**From:** dcregistration  
**Sent:** 02 December 2020 11:49  
**To:** DC Support  
**Subject:** FW: 20/02859/F - CDC Arboriculture

**From:** Iain Osenton <iain.osenton@cherwell-dc.gov.uk>  
**Sent:** 02 December 2020 10:59  
**To:** Planning <Planning@Cherwell-DC.gov.uk>  
**Cc:** dcregistration <dcregistration@Cherwell-DC.gov.uk>; Gemma Magnuson <Gemma.Magnuson@cherwell-dc.gov.uk>  
**Subject:** 20/02859/F - CDC Arboriculture

LOCATION and SITE PLAN As Existing & As Proposed  
1:1250 & 1:500 TPH October 2020  
(Original at A1) Drwg no. 20.192.01 Rev A

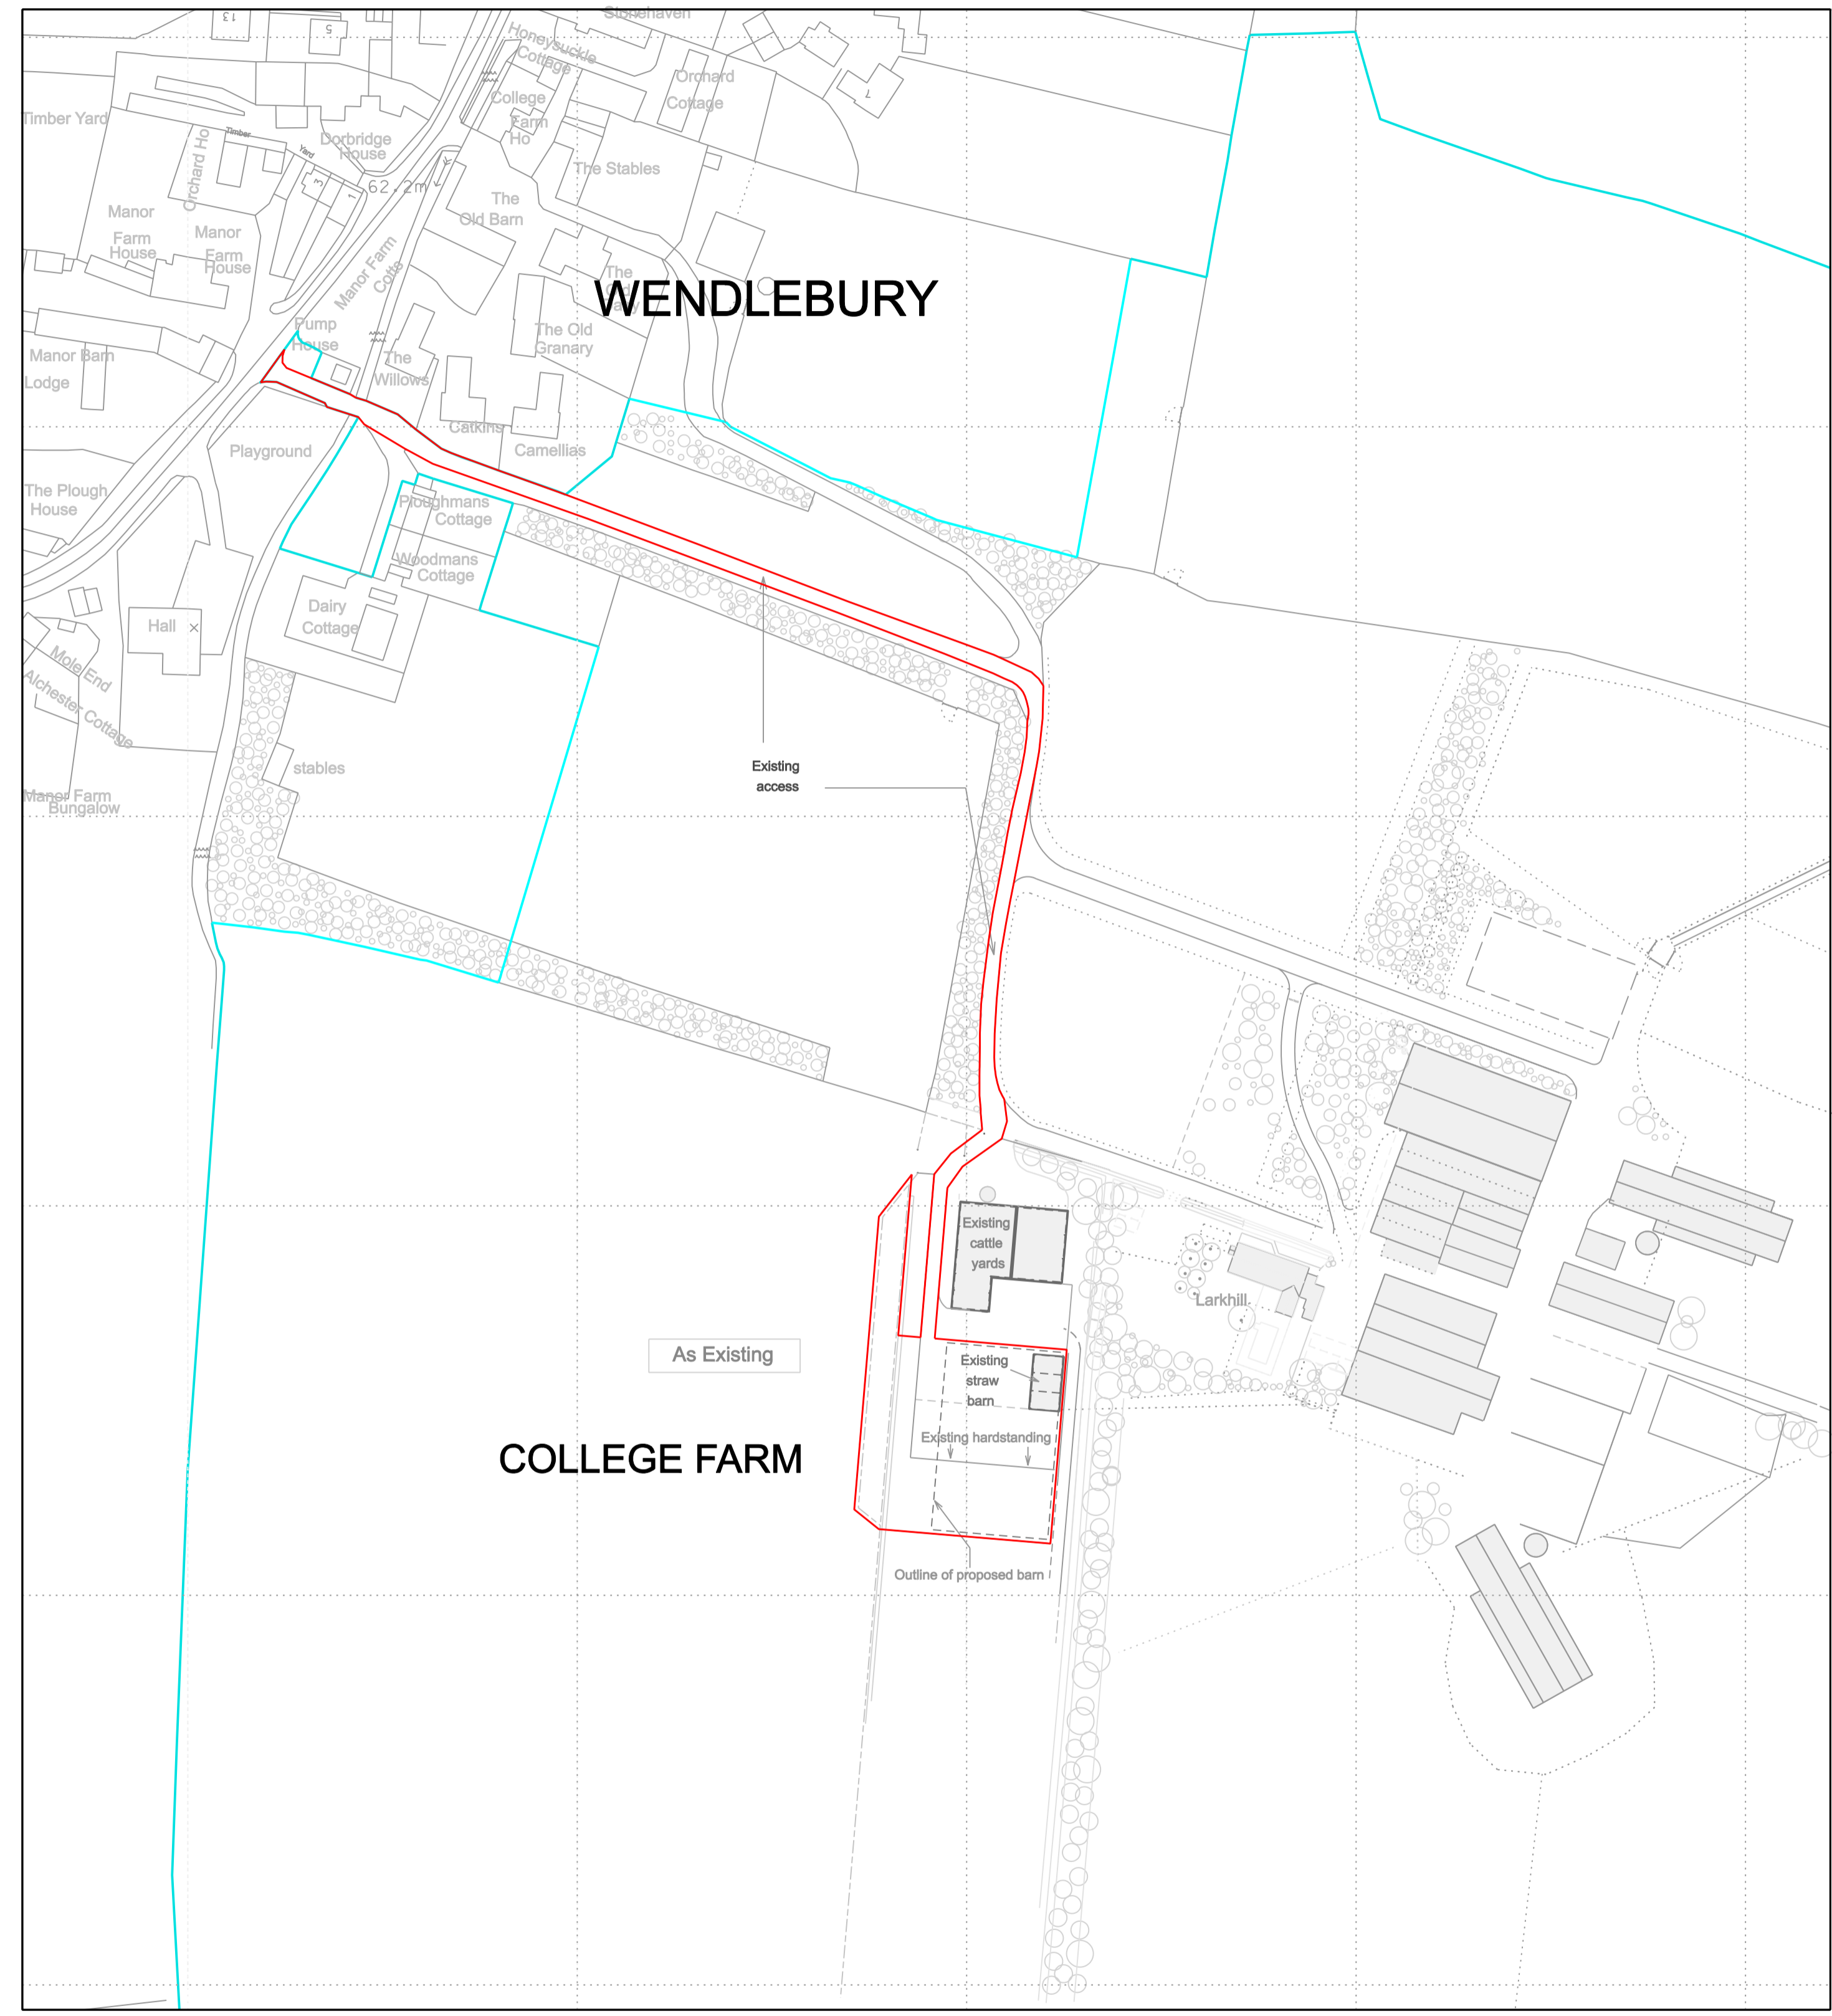
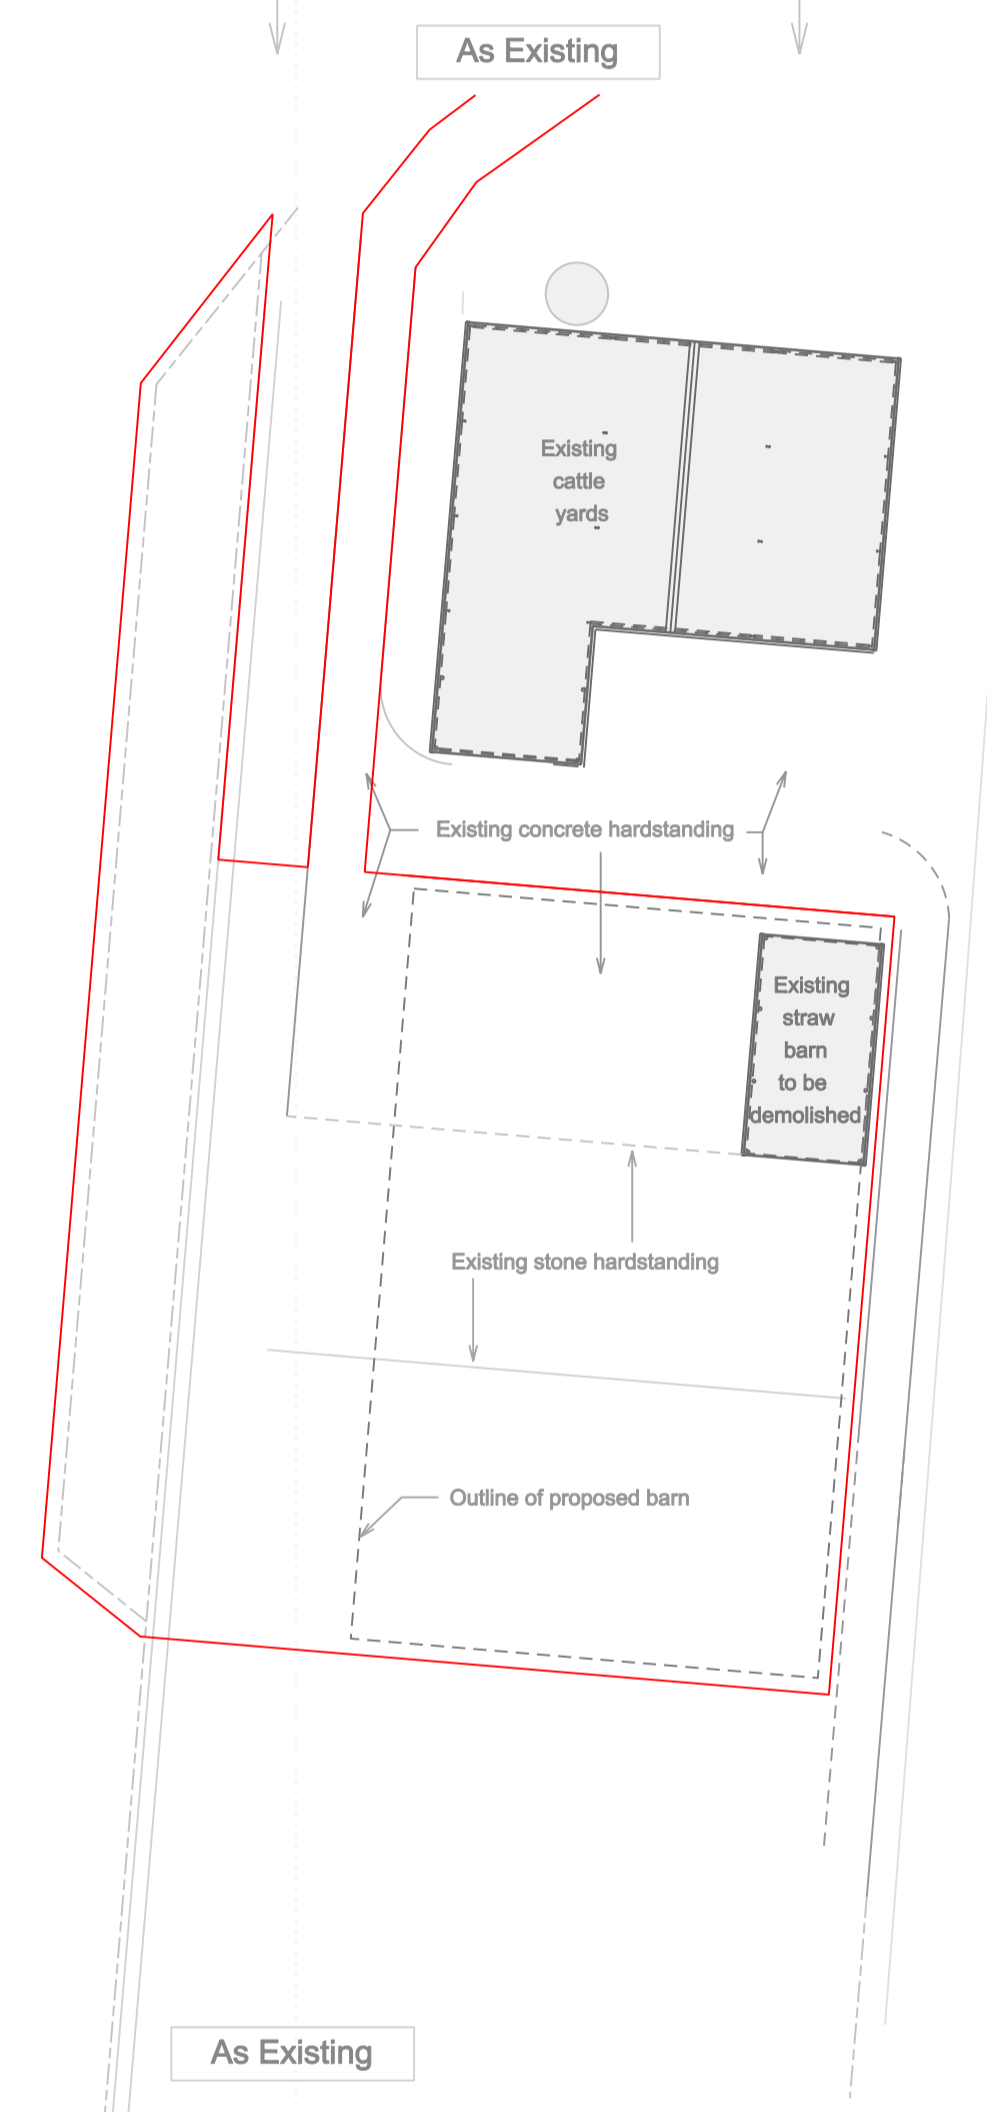
Reviewing the site plans, and D&A statement. The proposal sits to the west of a semi mature woodland group. Whilst I don't feel this will pose a constraint to the development, I would like to know if it is planned to retain these trees, or remove some in order to facilitate the proposal. Equally, if trees are to be retained, what protective measures will be afforded to them?

I appreciate planting is proposed to the west of the proposal, which will in time screen it. However, this will of course take time to establish and does not offer immediate mitigation for any existing trees which are removed, or damaged by development.
